Project # 1007367

Project Name: LANDS OF JOEL P. TAYLOR

Subject: Project #1007367, Site Development Plan for Building Permit, Riverside Church of Christ

**RE: DRB Final Sign-off of EPC Approved Site Development for Building Permit
Legal Description: A-1-B, Lands of Joel P. Taylor
Project # 1007367**

<b>RIVERSIDE CHURCH</b> ALBUQUERQUE, NM	DRAWN BY pm
	<b>GRADING AND DRAINAGE PLAN</b>	DATE 10-13-08
<b>TIERRA WEST, LLC</b> 5571 MIDWAY PARK PLACE NE ALBUQUERQUE, NM 87109 (505) 858-3100		2831-GRE
RONALD R. BOHANNAN P.E. #7868		SHEET #
		JOB # 28031

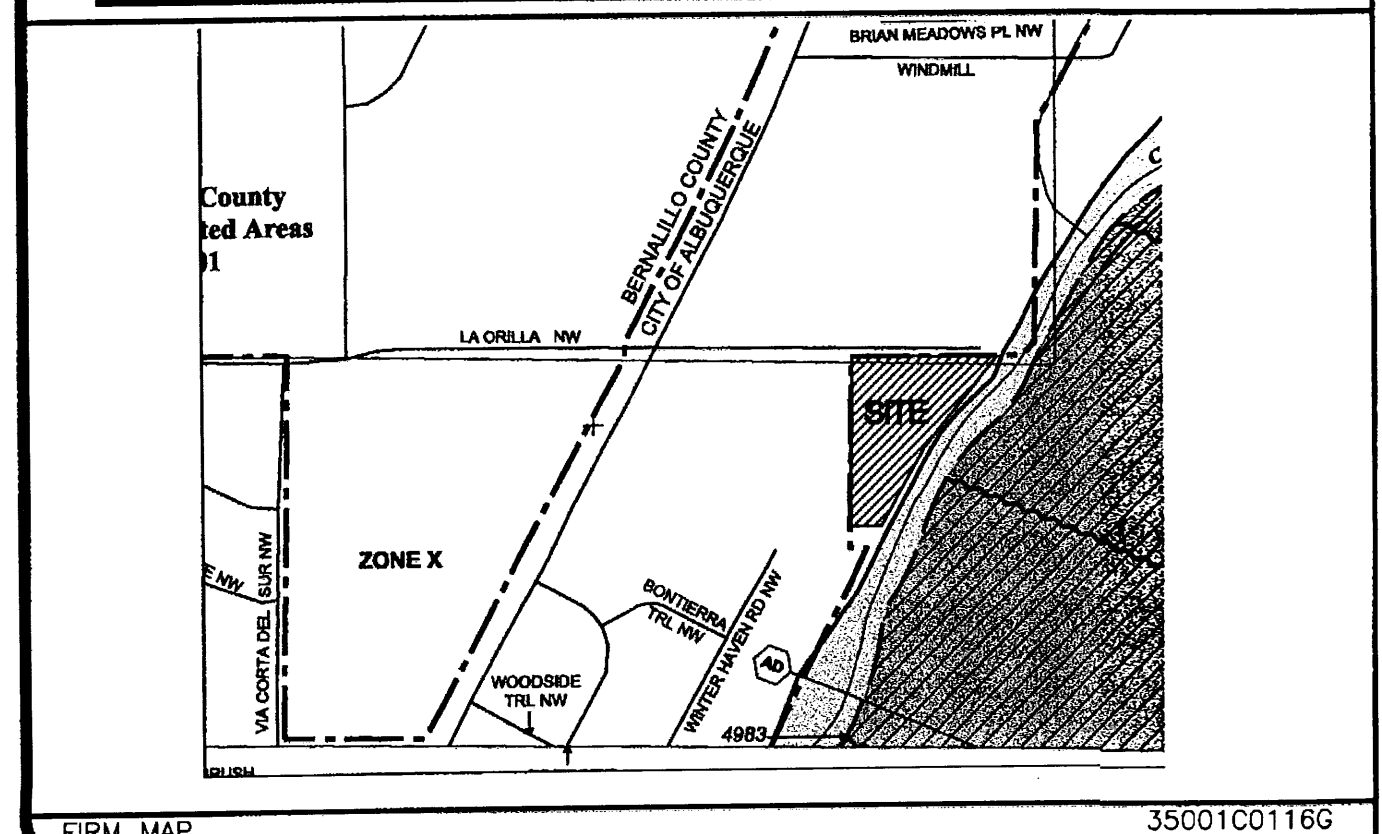
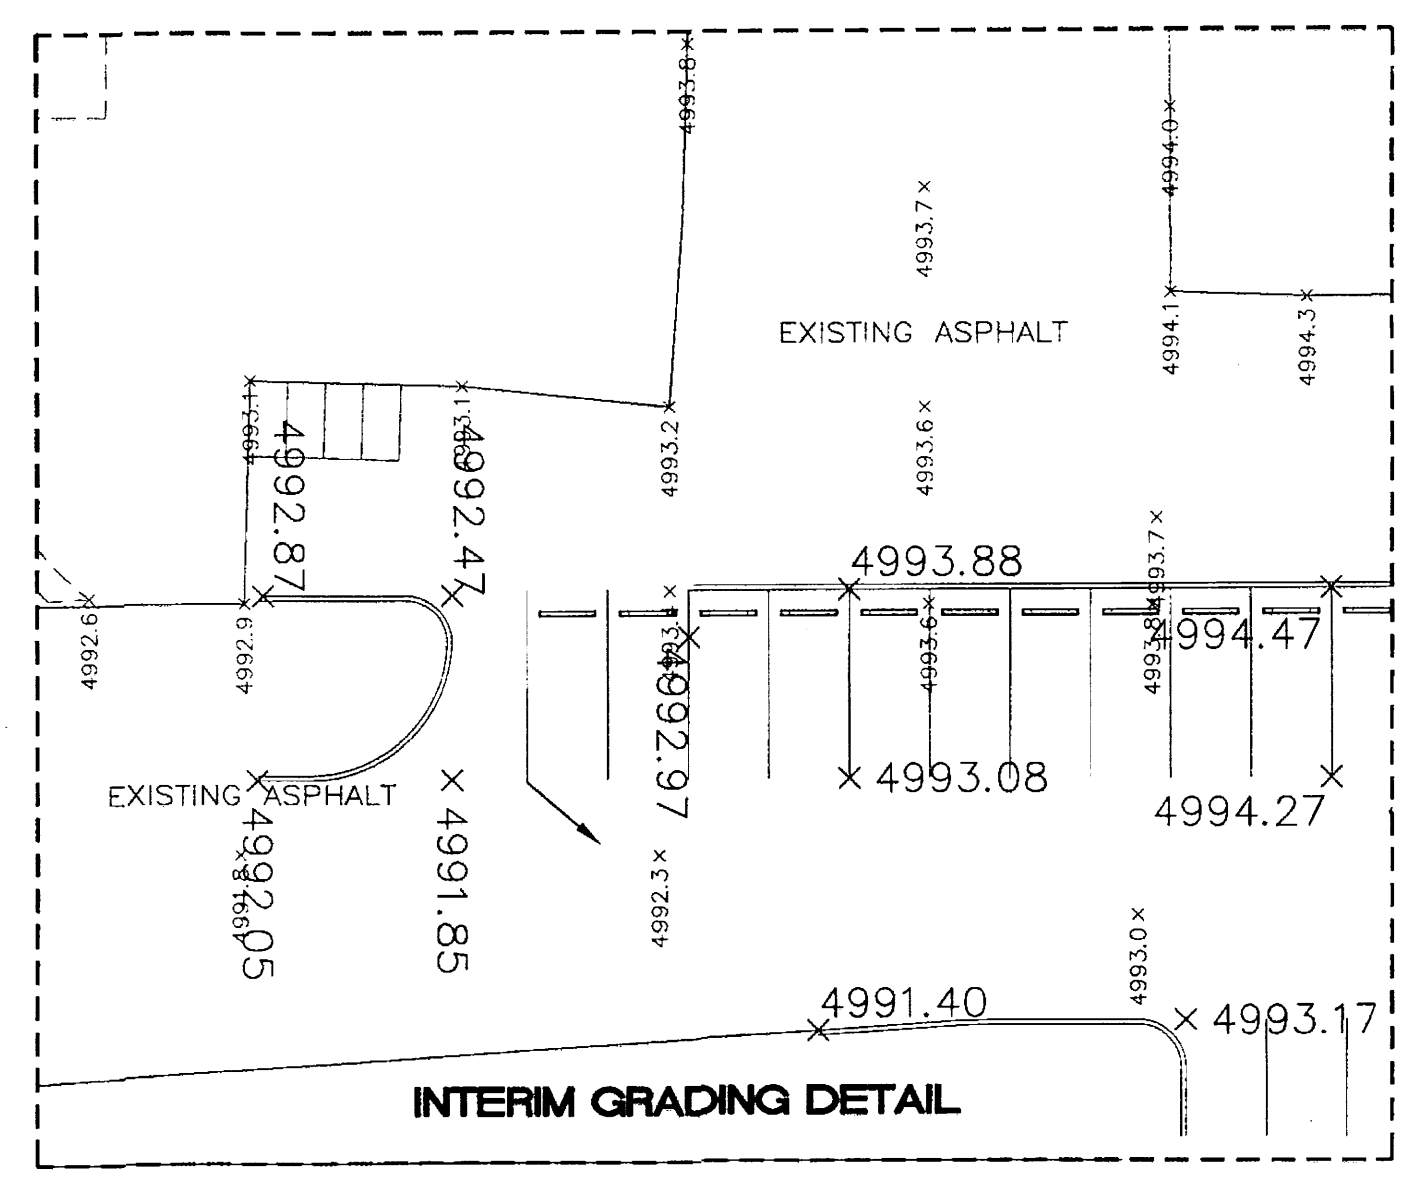
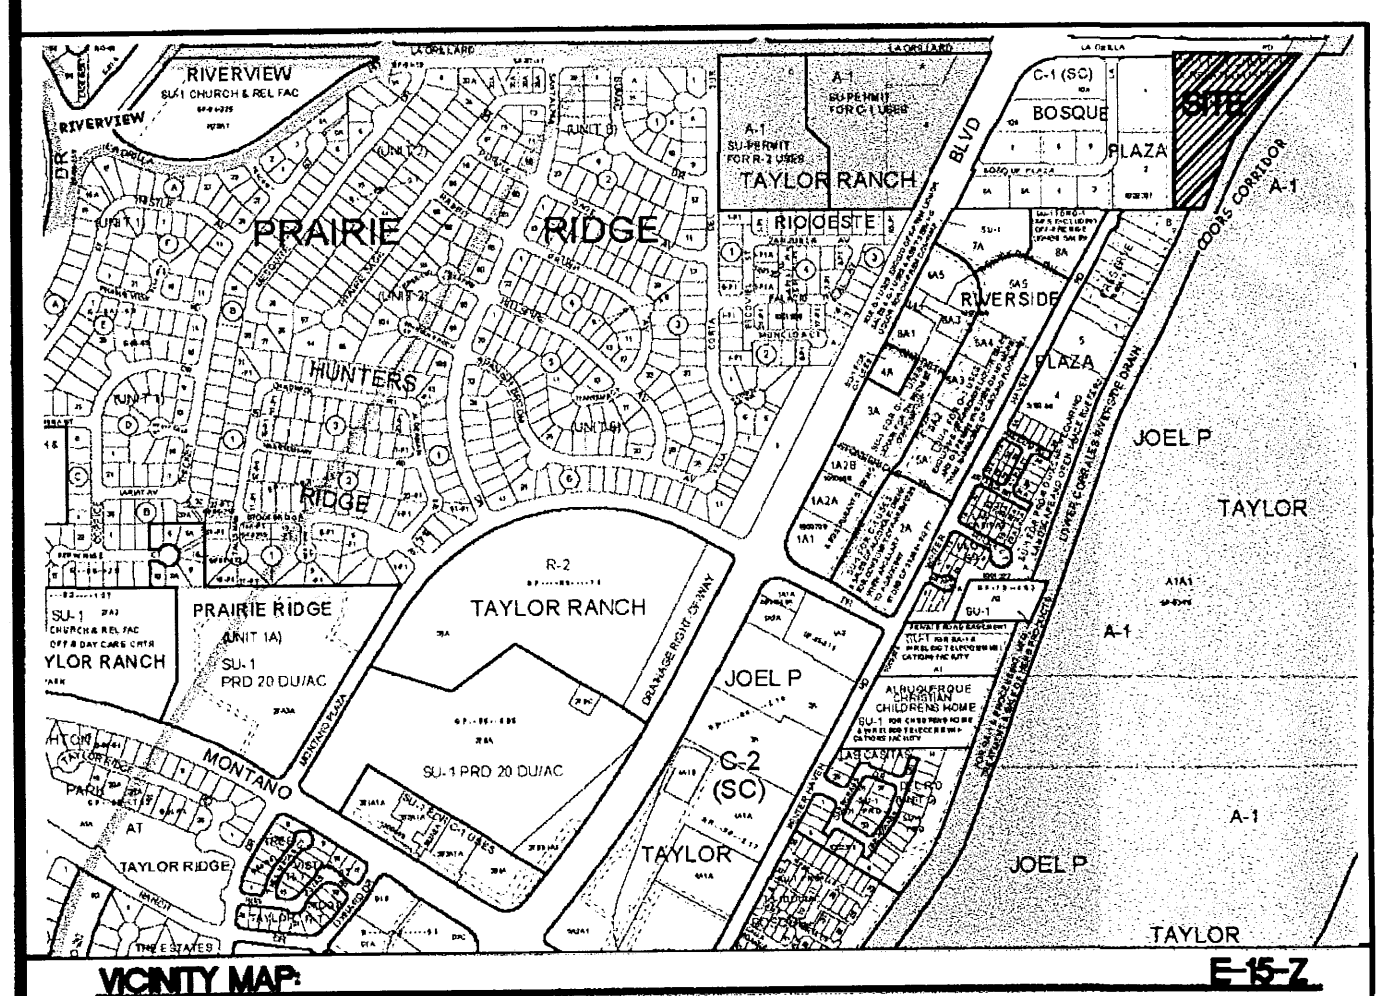
7. Grading & Drainage:
- a. Correct location of site on vicinity map.
This is corrected.
 - b. Eliminate "future path" indicated along Corrales Riverside Drain.
This note is removed as shown on Sheet C1.
